**Rezoning Transportation Analysis**  
**Petition Number: Insert Zoning Petition #2020-181**  
*General Location Identifier: 11122105*

**Revision Log:**

Date	Description
01-21-21	First Review (WB)
02-15-21	Second Review (WB)
04-23-21	Third Review (WB)

RZ-3

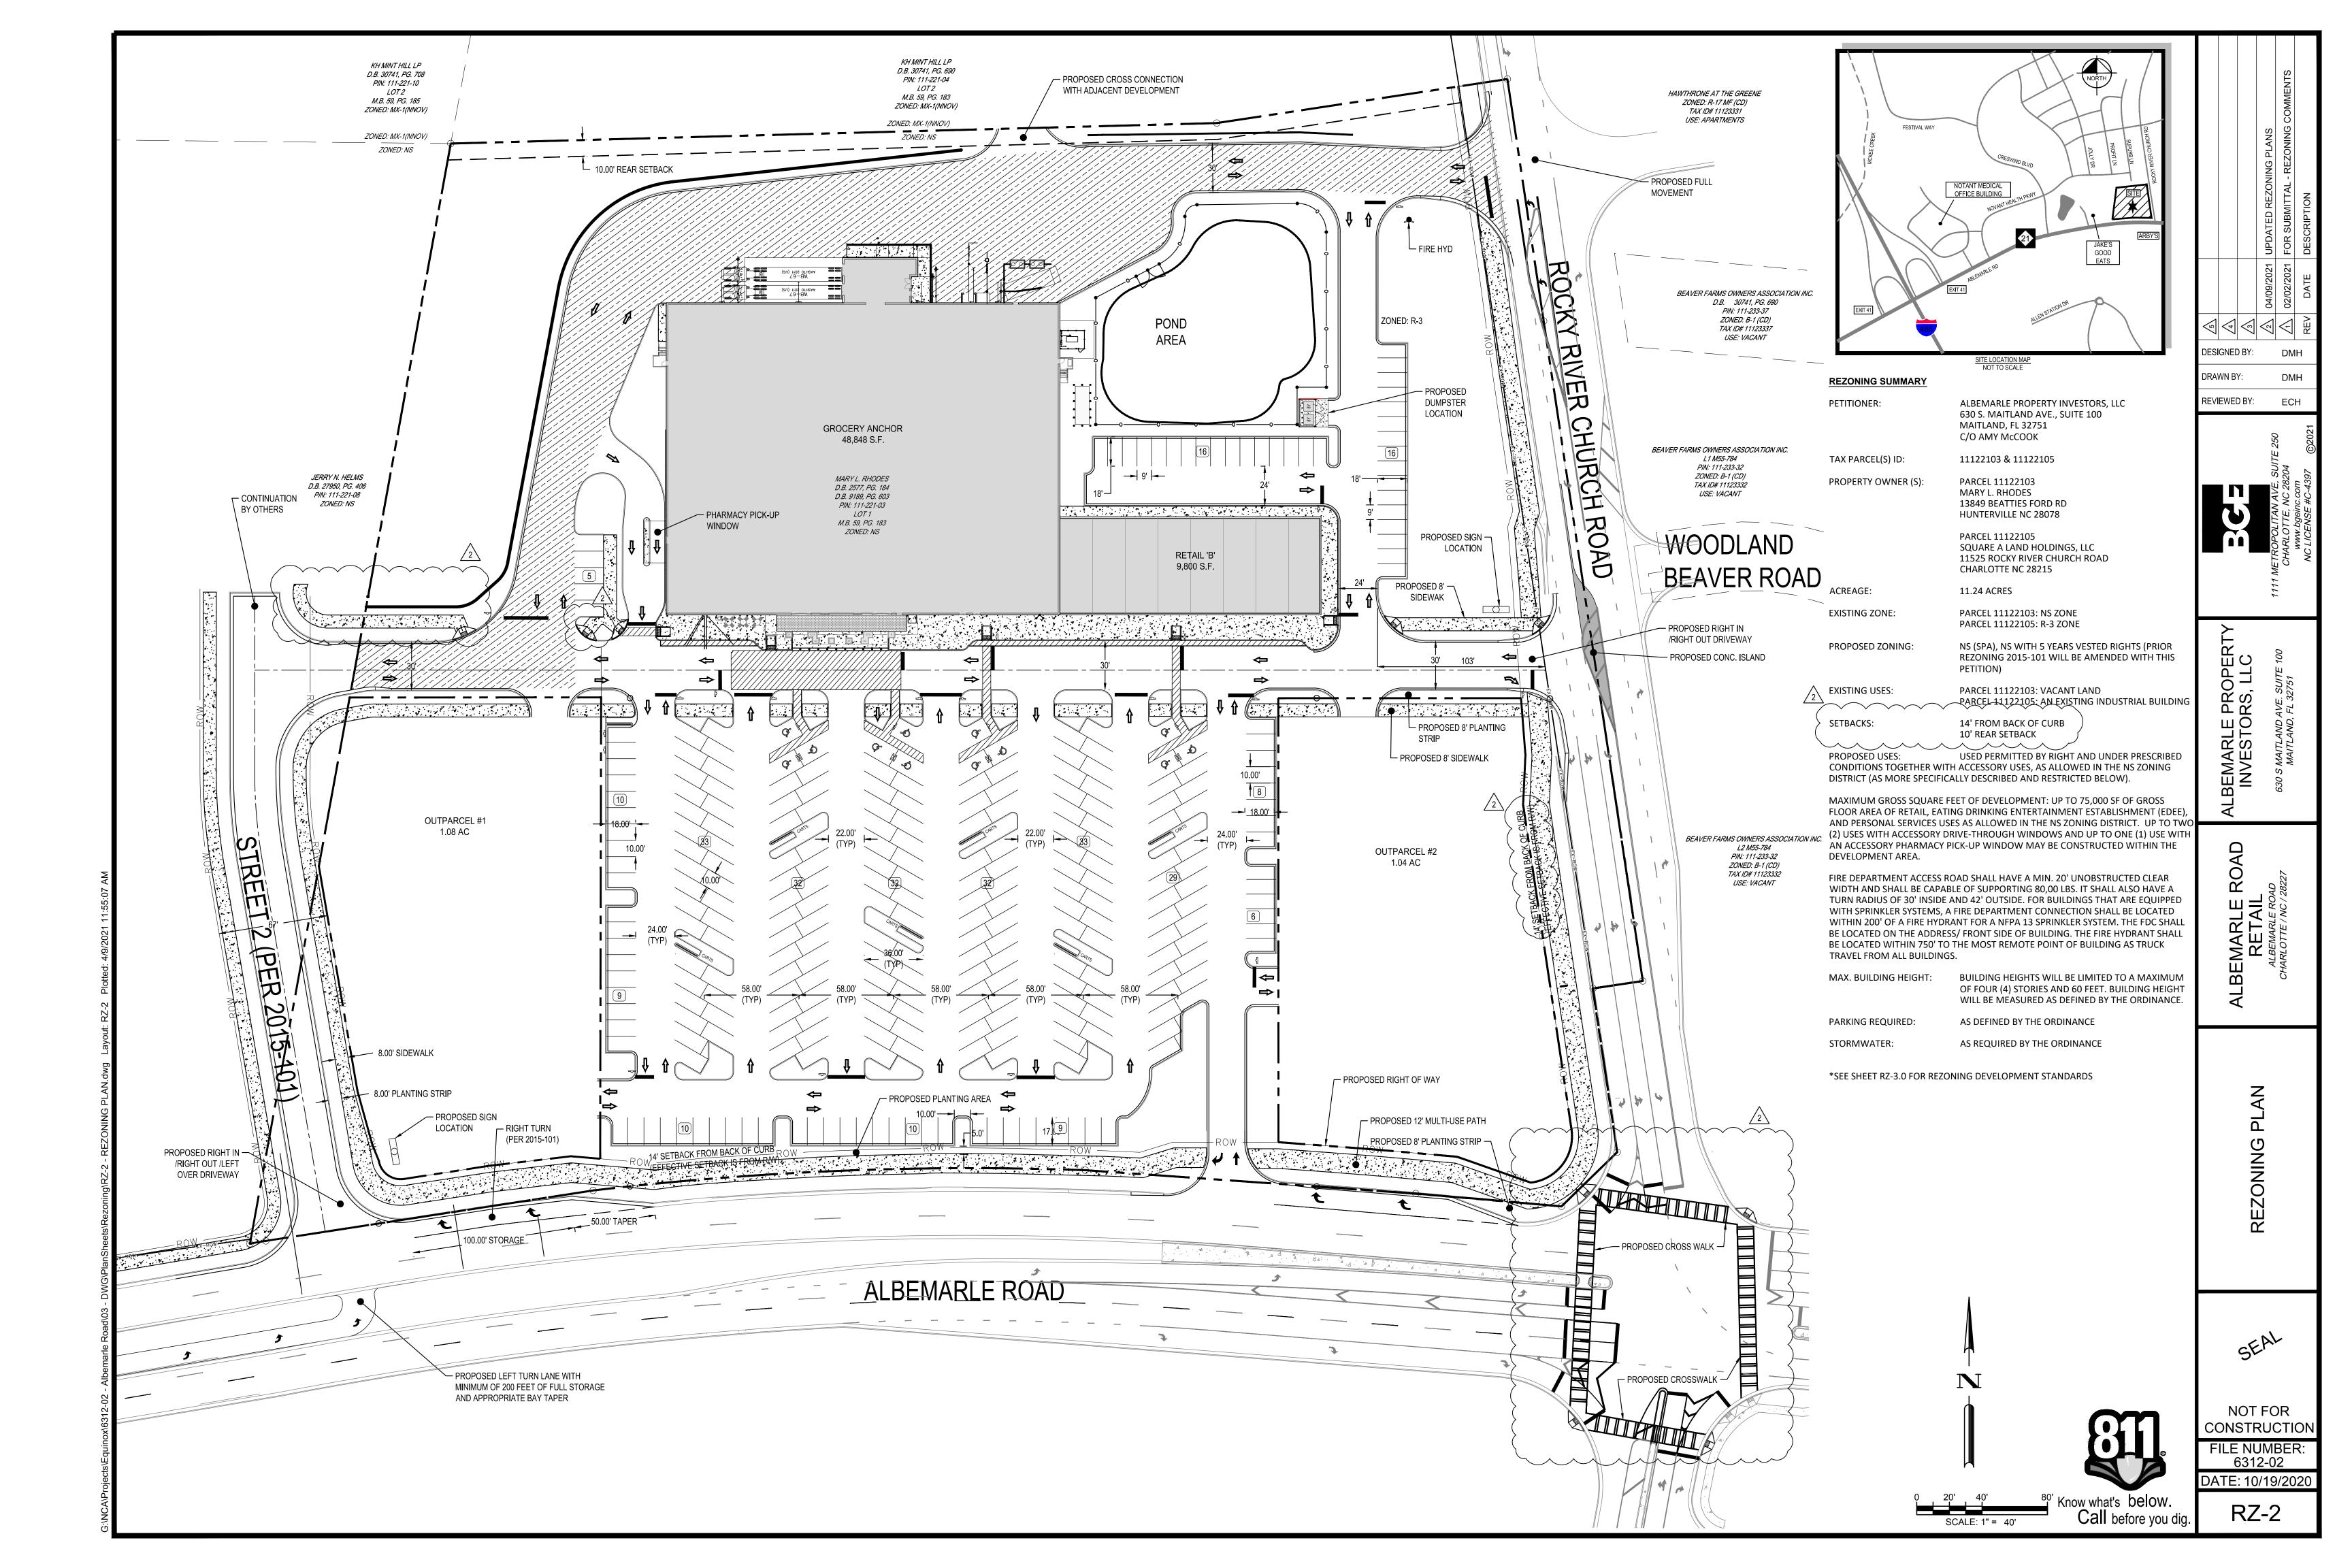
3. **Comment Revised (based on Comment review meeting held on 2/5/2021).**

Revise site plan to label and dimension the dedicated the Public Street right of way 2 per Rezoning Petition 2020-101. Street 3 will be constructed as a private street; however, the petitioner shall provide pedestrian connectivity on the south side of the proposed street. The site plan shall label and dimension an 8-foot planting strip and an 8-foot sidewalk on Street 2 and on the south side of Street 3.

- 6. Site plan and conditional note(s) revisions are needed to commit to providing intersection improvements to accommodate pedestrian and bicycle crossings at the Albemarle Road and Rocky River Church Road Intersection. These improvements shall include accessible ramps, channelization islands and all associated infrastructure modifications needed to provide a safe route for both bicyclists and pedestrians and align with those improvements found and approved as part of RZP 2020-007.

Add conditional note to commit to providing intersection improvements to accommodate pedestrian and bicycle crossings at the Albemarle Road and Rocky River Church Road Intersection. These improvements shall include accessible ramps, channelization islands and all associated infrastructure modifications needed to provide a safe route for both bicyclists and pedestrians and align with those improvements found and approved as part of RZP 2020-007.
